ARACO CONCRETE

SITE DEVELOPMENT PLAN EL PASO COUNTY, COLORADO

Site Development Plan_V3.pdf Markup Summary

ARACO CONCRETE
SITE DEVELOPMENT PLAN
A PORTION OF THE SOUTHEAST QUARTER OF SECTION 24,
TOWNSHIP 15 SOUTH, RANGE 66 WEST OF THE 6TH P.M.,
EL PASO COUNTY, COLORADO

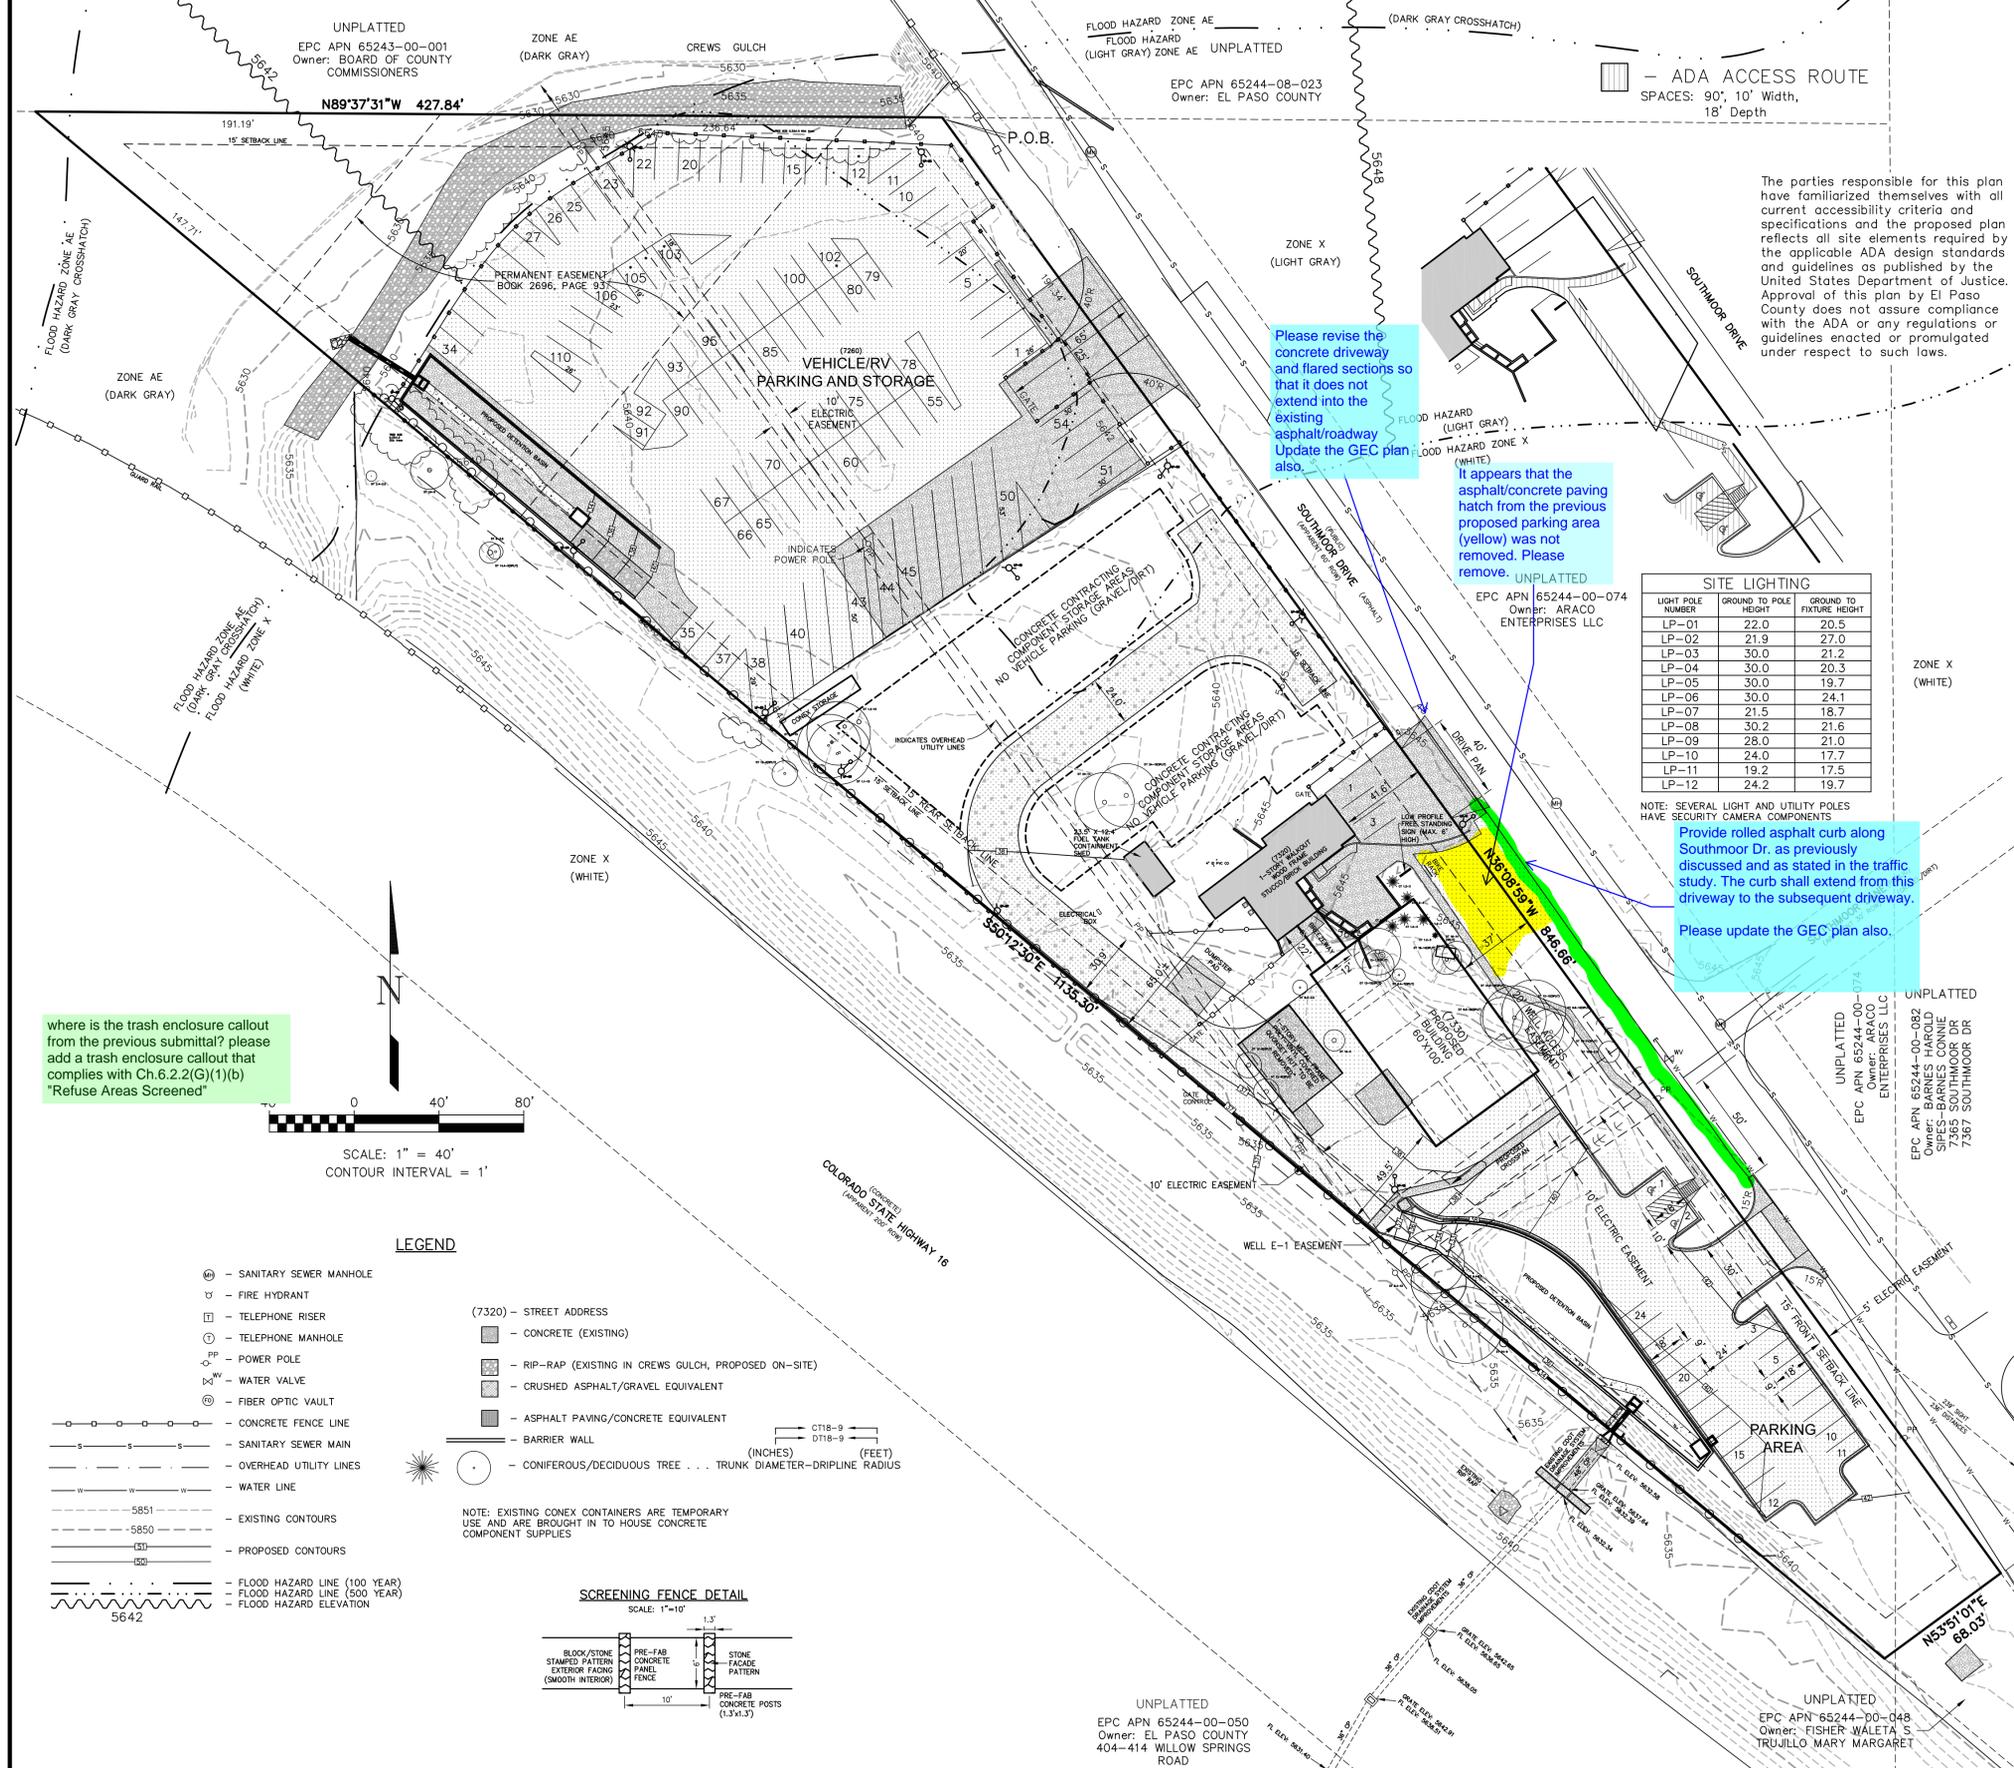
the engineering manager is amenable to a 3rd access point although the driveway shall be limited to 40' wide per criteria. Currently the driveway shown is +111'. Provide the appropriate curb/gutter at this location such that the driveway is limited to max 40' wide. Additionally, a sign indicating that there shall be no backing into Southmoor drive shall be provided. Staff has discussed this information with your traffic engineer.

The dumpster enclosure appears to be enclosed / screened on only 3 sides and is also unclear as to the direction and whether there is a gate to the enclosure or if the front is open, etc. (though it is difficult to verify all this via the detail).

Please either clarify in your dumpster enclosure callouts, or revise the proposed dumpster enclosure, to comply with Ch.6.2.2(G)(1)(b) "Refuse Areas Screened"

Review 1 comment:
The TIS shall provide recommendation for the gate location. The design of this access must ensure sufficient queuing without blocking the road. Please incorporate the traffic engineers recommendations into the design of this access.

Review 2: Unresolved. Per the Traffic Study a distance of 65' between the entry gate and Southmoor Drive should be provided. Please incorporate the traffic engineers recommendations and revise the design accordingly.

The traffic study indicates a 24' wide driveway. Note that the minimum per County criteria (ECM 2.4.1.E) is 25'. A deviation request would be required for a smaller width. Be aware that submittal of a deviation request form does not imply that it will be approved by the ECM administrator. Proper justification must be supplied and a decision will be made by the ECM administrator after review of the deviation request.

Review 1: Note that Southmoor drive is classified as a Collector. Per County criteria access is not permitted. The proposed access points have been discussed with the engineering manager and we have determined that a total of 2 access points will be allowed. Please revise the site plan accordingly. Ensure that the proposed access points meet ECM criteria (see ECM 2.4.1). Coordinate with the traffic engineer.

Review 2: Unresolved. There are still greater than 2 access points shown on the plan (north access, head-in access near the existing/proposed building and south access). As indicated in the review #1 comment, only 2 access points will be allowed. Revise the site plan accordingly.

Please identify the surface material of the storage areas

Provide a detail for the trash, where the dumpsters will be stored, how they will be screened and the dimensions of the screening.

Please label this storm facility and indicate it as existing.

Please indicate the dimensions of the various parking stalls

Revised design - DVH

Revised per Deviation Request - DVH

IDENTIFIED - DVH

Provided - DVH

Labelled - DVH

Indicated varying distances, together w/ Site Data note for minimum sizes - DVH
